TfNSW Reference: SYD21/00462  
Departments Reference: SSD-17647189

**REQUEST FOR SEARS – ACCESS LOGISTICS PARK - 884-928 - MAMRE ROAD, KEMPS CREEK**

Reference is made to the Department's correspondence dated 16 April 2021, requesting Transport for NSW (TfNSW) to provide details of key issues and assessment requirements regarding the abovementioned development for inclusion in the Secretary's Environmental Assessment Requirements (SEARs).

LOT 2 - Site Plan / Ground Floor Plan / Fencing Plan

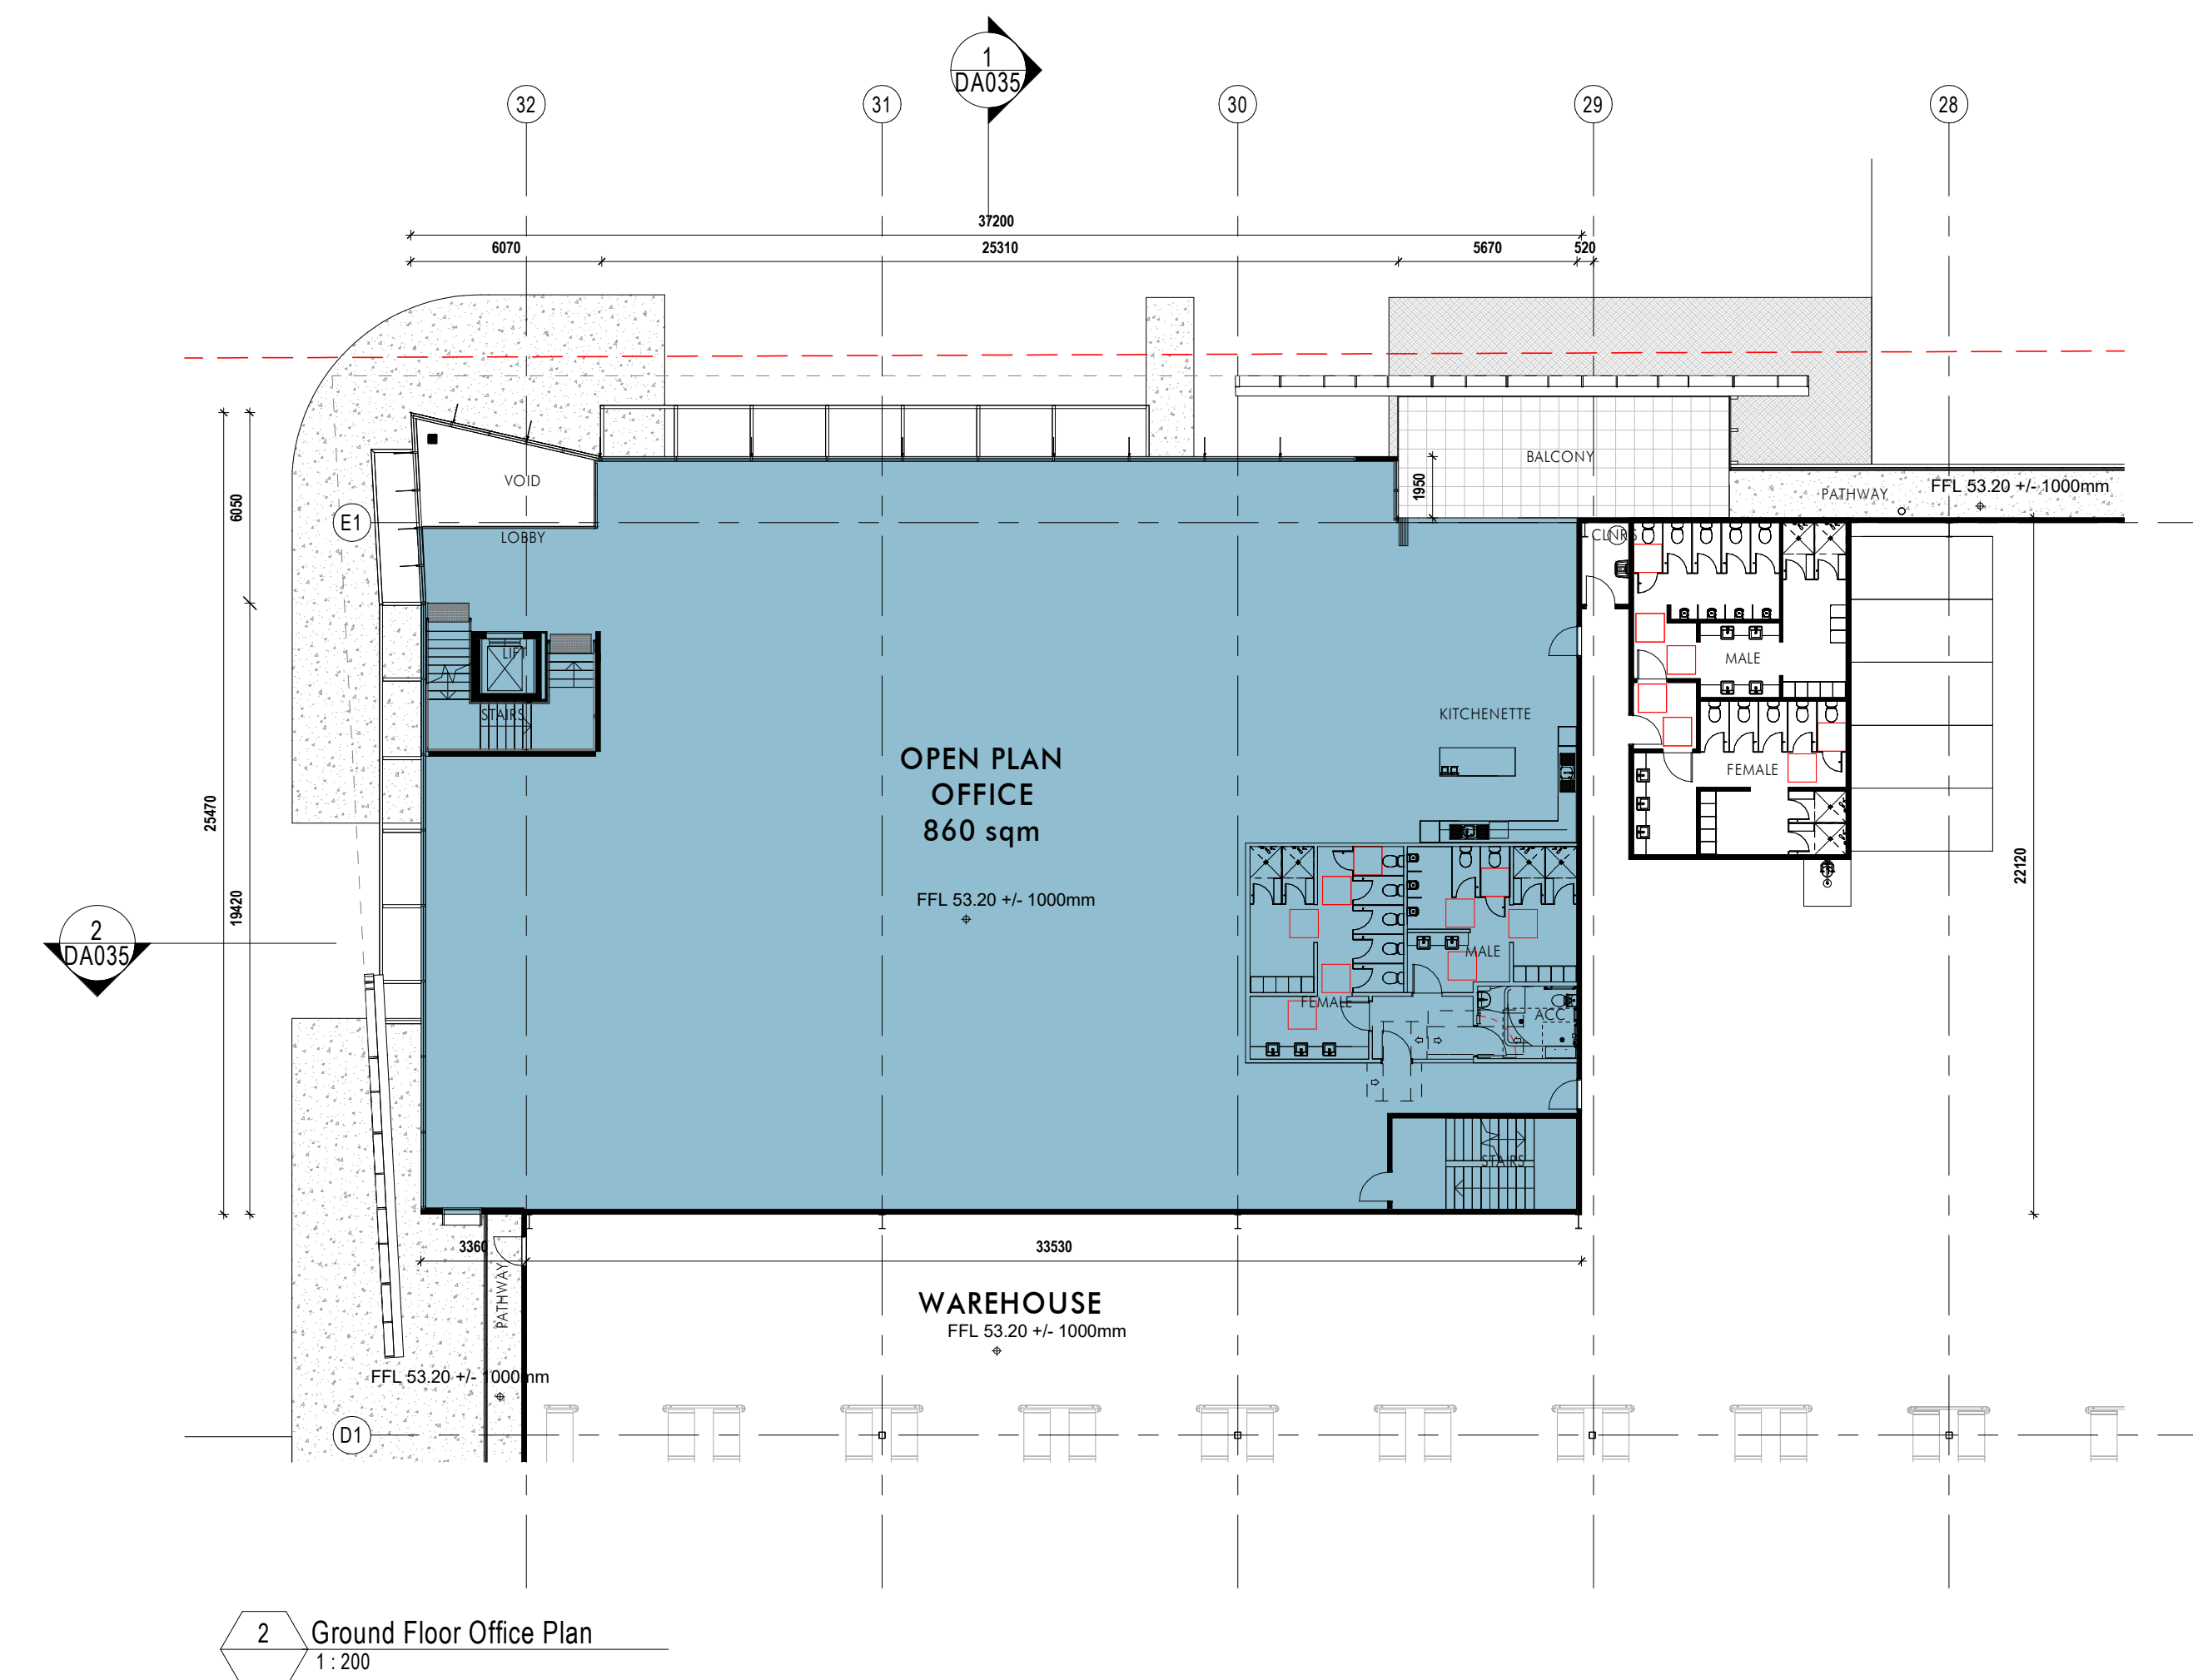
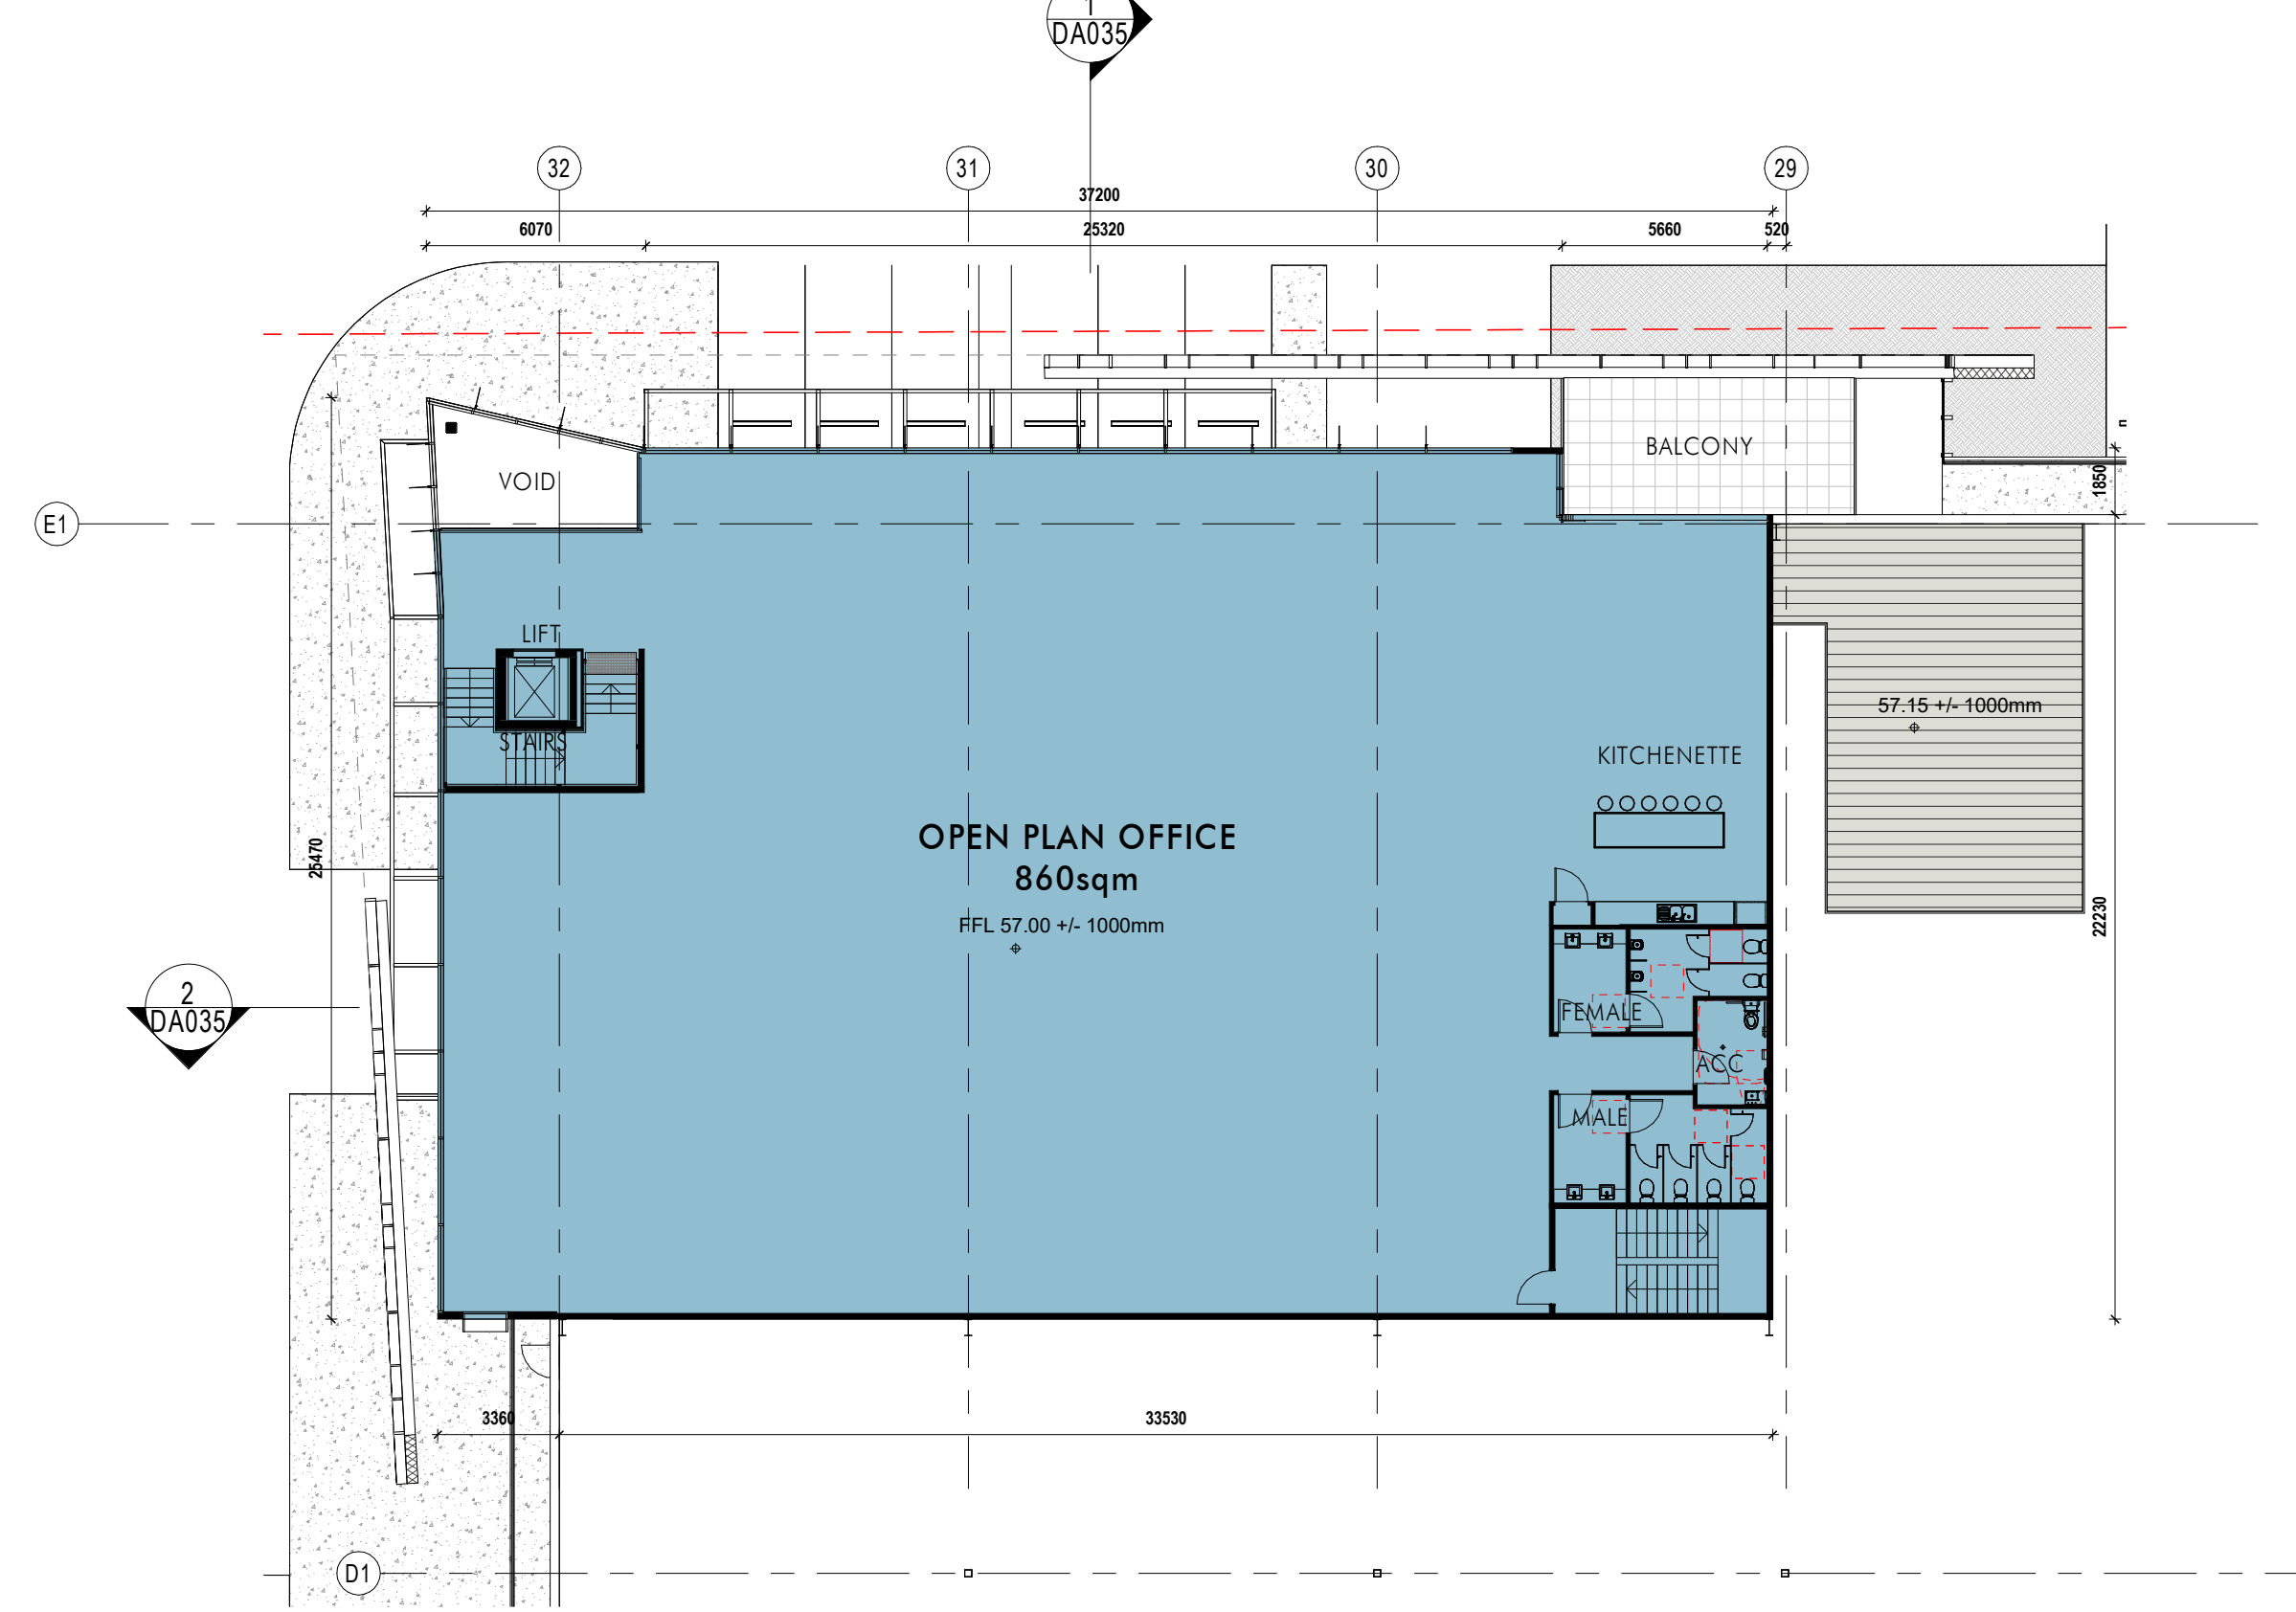
The preliminary site plan proposes a signalised intersection with Mamre Road at the southwest corner of the site. These signals are not inclusive on TfNSW Mamre Road upgrade strategic plan, however it is noted that they are proposed in the Mamre Road Precinct draft Development Control Plan (DCP). It is understood that the DCP has not yet been finalised and that currently there is an active investigation by AsonGroup on behalf of the Land Owners Group into whether signals at this location are warranted to alleviate traffic from other intersections along Mamre Road.

In this regard, subject to the finding of the traffic modelling investigations, TfNSW recommends that alternative options are investigated and modelled for review. This should include but not be limited to a temporary access from Mamre Road until the ultimate local road network is delivered and the connection to ultimate local road network with no access to Mamre Road.
